**Recommendation:** Refusal

**Applicant:** Mr Blackwell

**Proposal:** A single storey, connecting link between the garage and the original barn conversion dwelling.

<p>project Heath Barn Sibford Gower Banbury OX15 5HQ</p>	<p>drwg no 213_05_301 rev P1 title Proposed Elevations E + W scale 1:100 @ A3</p>
--	---

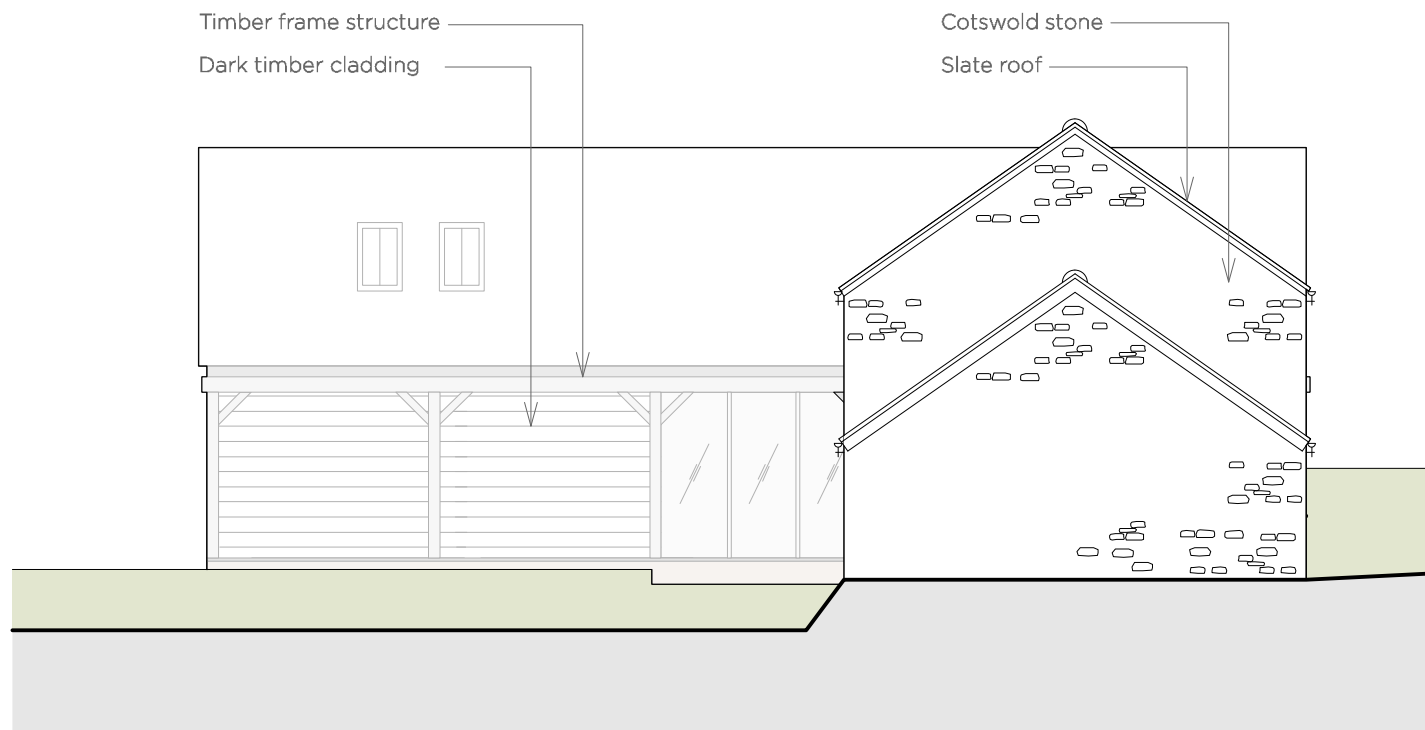
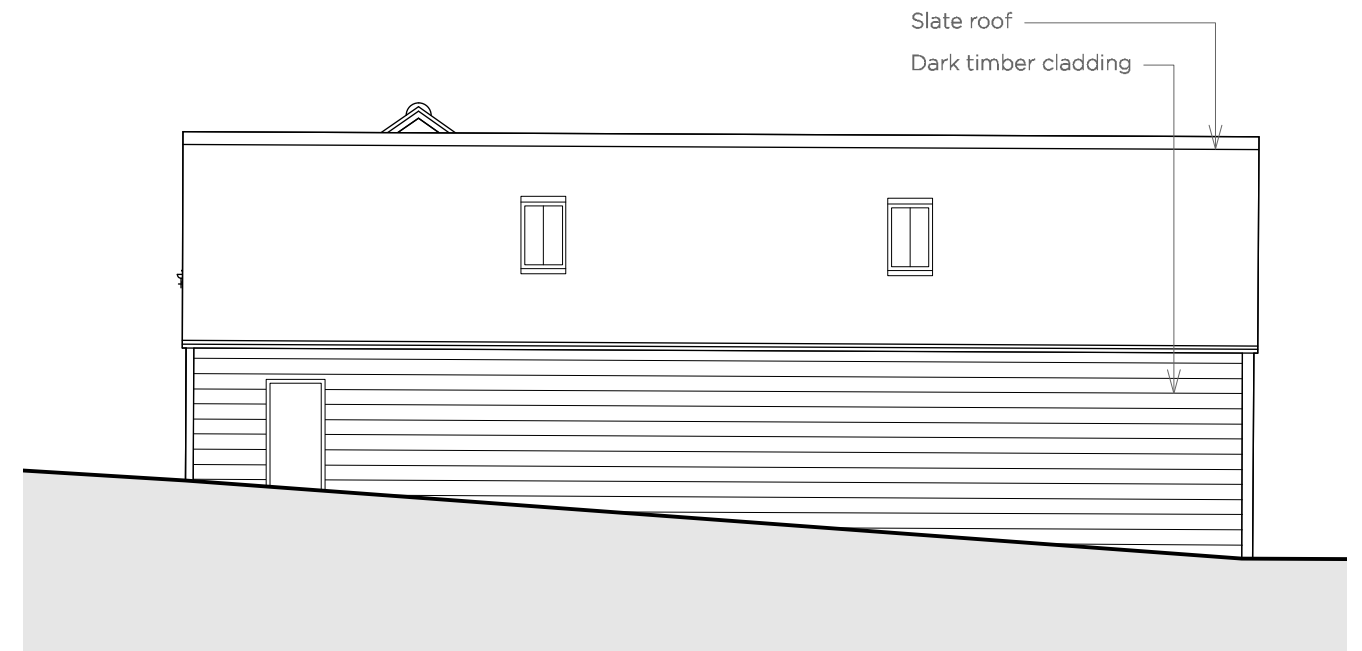
The issue is extending the existing historic barn in the countryside to the recent garage. This is contrary to policy and Cherwell's guidance on barns. The work would also involve new openings in the gable of the non-designated heritage asset and the light spill from the glazed link would emphasise the physical link.

Policy H19 Cherwell Local Plan 1996 states that barn conversions should be done *'without major rebuilding or extension and without inappropriate alteration to its form and character'*. The creation of an additional link between the two buildings would in my opinion constitute an unnecessary alteration to the form of the original barn.

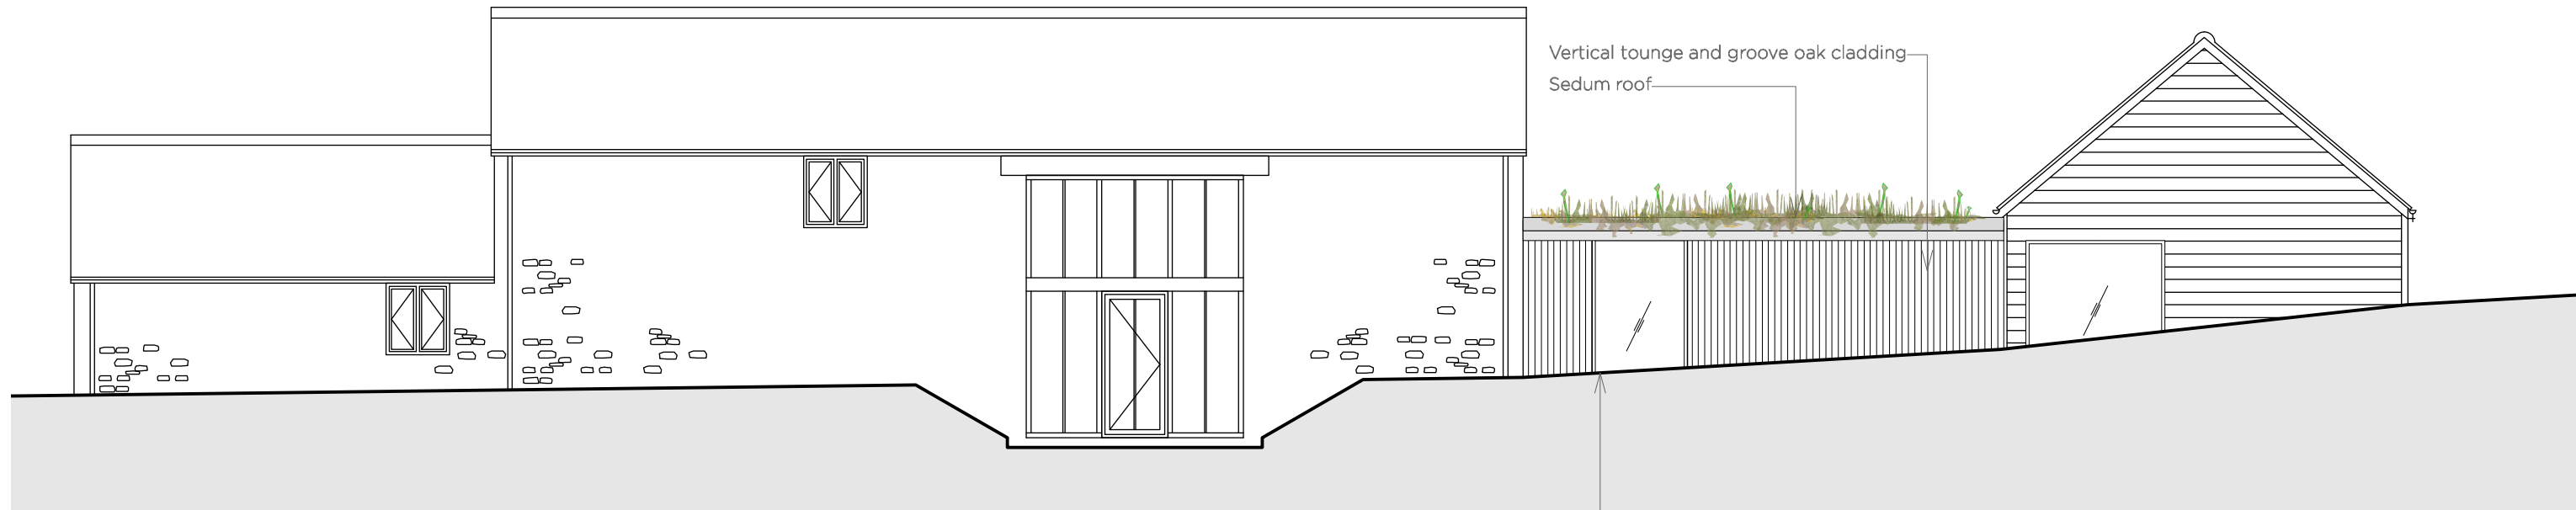
The roof is proposed to be a sedum covered green roof. The proposed design is largely glazed on the south elevation and would be constructed with oak framing and a vertical tongue and groove oak board cladding.

Whereas traditional timber cladding/constructed farm buildings in the district have horizontal timber boards, the proposals here are for vertical cladding. Whilst this ties

into the use of a similar style cladding on the existing garage/barn the material choice against the converted stone barn is

The proposal to link the non-designated barn to the detached outbuilding would alter the layout and form of the existing building. The 2012-14 conversion of the building was sensitively carried out and has largely preserved the special character and linear form of the agricultural barn. Both the double height threshing opening and the formerly open single storey element has glazed units in the openings. Elsewhere the addition of domestic style openings has been kept to a minimum.
